Tel: 01903 737756
Email: planning@arun.gov.uk
www.arun.gov.uk/planning
Please ask for: Mrs D Johnson
Email: daun.johnson@arun.gov.uk
Telephone: 01903 737762
Our Ref: EP/43/26/PL
Your Ref:
Date: 13th May 2026

Application for Planning Permission

Development: Ground floor alterations and extension within an internal courtyard. This application is in CIL Zone 4 (Zero Rated) as other development.
Location: Green Willow Care Home 21-23 Vicarage Lane East Preston BN16 2SP

Drawing Name
Ground Floor Plan & Courtyard Elevations -
Existing

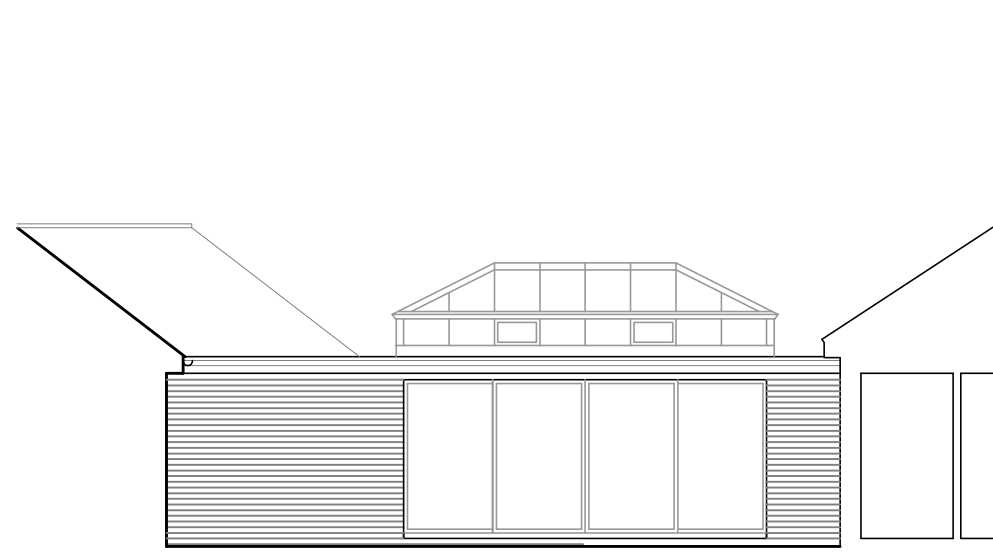
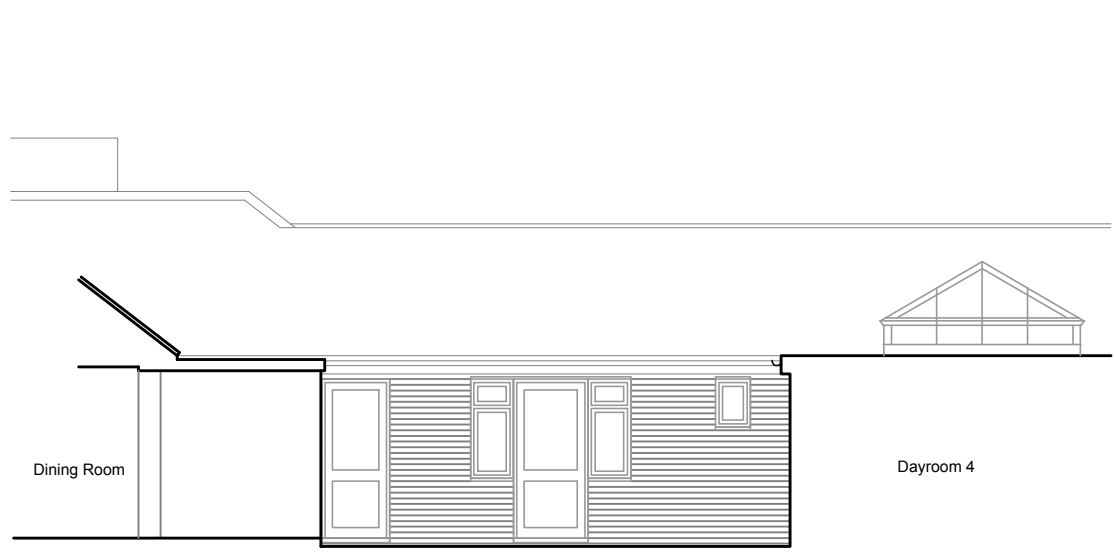
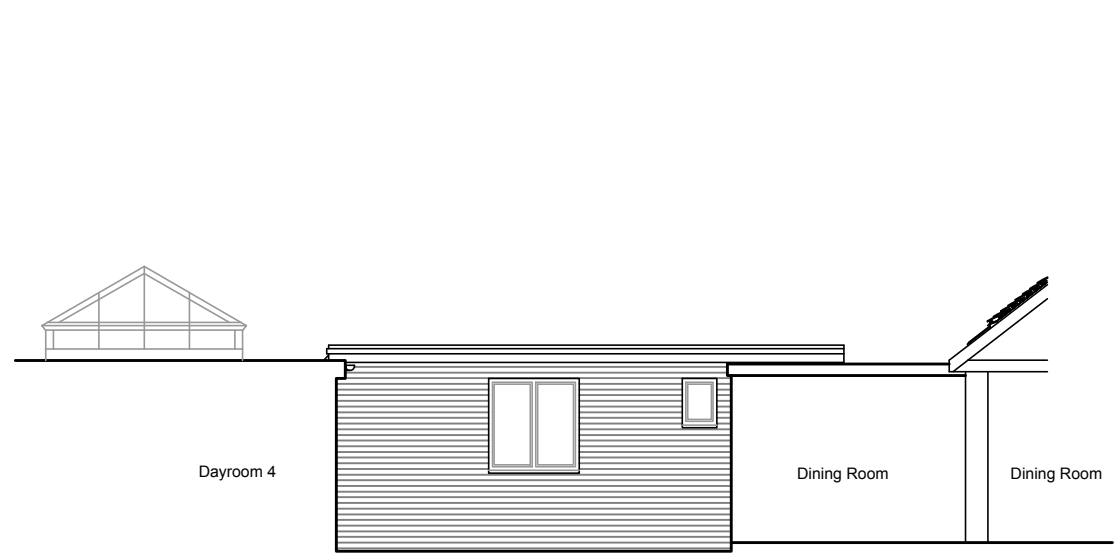
The existing and proposed elevations are labelled incorrectly. Please amend accordingly.
